RE: REVISED DRAINAGE PLAN FOR PARADISE VISTA SUBDIVISION (B11-D2A)
REVISION DATED 10/16/97

RE: Paradise Vista Subdivision (B11-D2A) Grading and Drainage Plan

This letter is in response to your comments dated September 16, 1997. I would like to thank you for faxing your comments to me to help speed up the revision process. Hopefully, the following will alleviate any concerns you may have so that we may gain approval and move on to DRB with this project.

Basin B & C Public Easement
N.T.S.

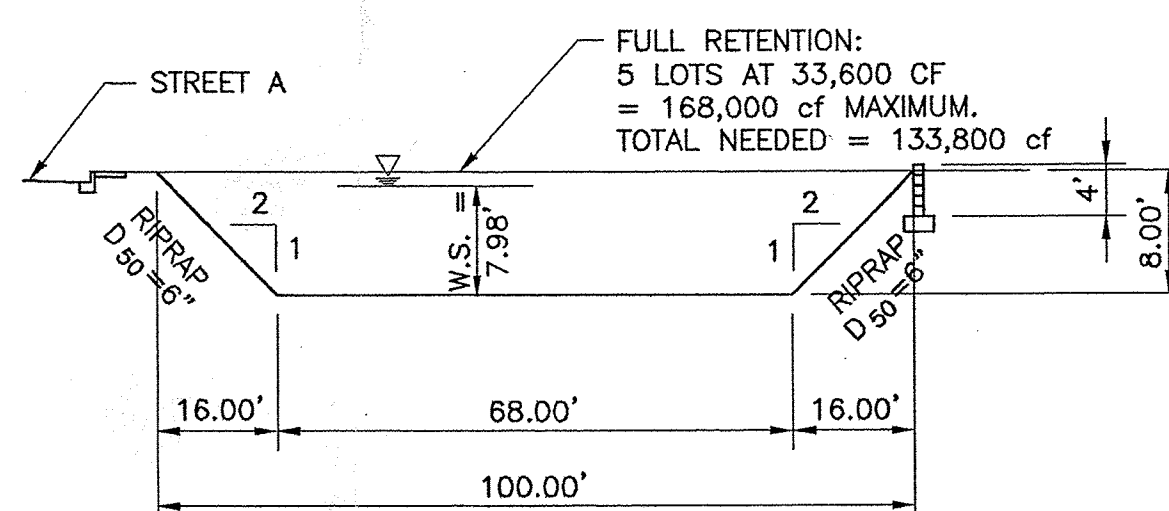
10. The drainage easements will be public and are designed as shown on the plan conforming to COA standard drawing 22-60. The ten foot easement will be concrete lined with an eight foot bottom, one foot deep and will flow the fully developed runoff rate at about 0.4 feet. The EGL was calculated as 0.7 feet, thus maintaining any potential hydraulic jump to be maintained within the curbs on each side of the street.

Basin B & C Wall Opening Detail
N.T.S.

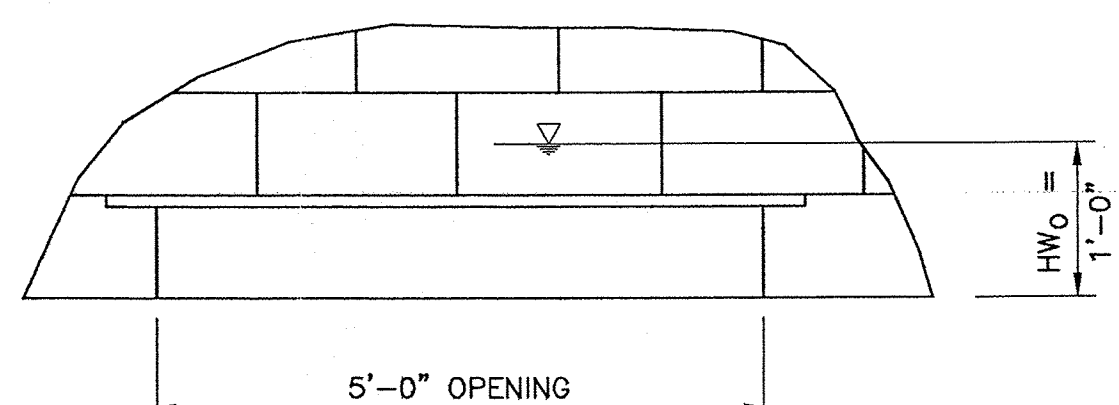
- ok 2. After further analysis, it was found that the fully developed flow can be carried in the streets through the subdivision. The EGL in the streets is still well below the right-of-way limits. The wall openings to the easements were estimated assuming a five foot wide by one foot high box culvert calculation. These spreadsheet printouts are included with this letter. The permanent drainage easements are ten feet wide and one foot high and will flow at a depth of about 0.4-feet during the fully developed 100-year storm.

SIDE LOT SWALE DETAIL
N.T.S.

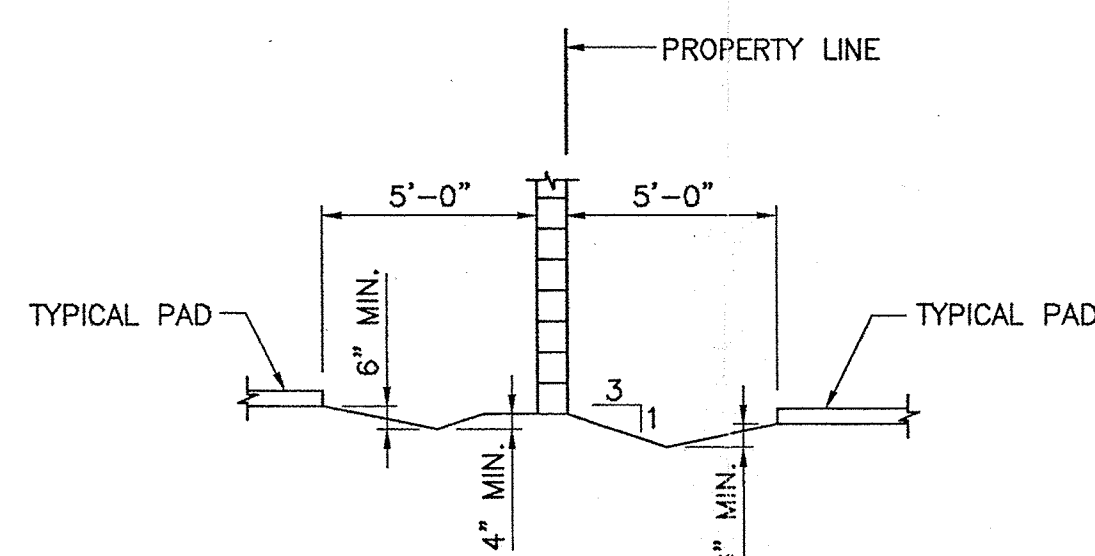
- ok 3. All pad elevations have been converted to MSL.
 - ok 4. The typical detail for side lot swales is shown on the plan.
 - ok 5. A note for concrete grouting of the rundowns has been added to the plan.
-
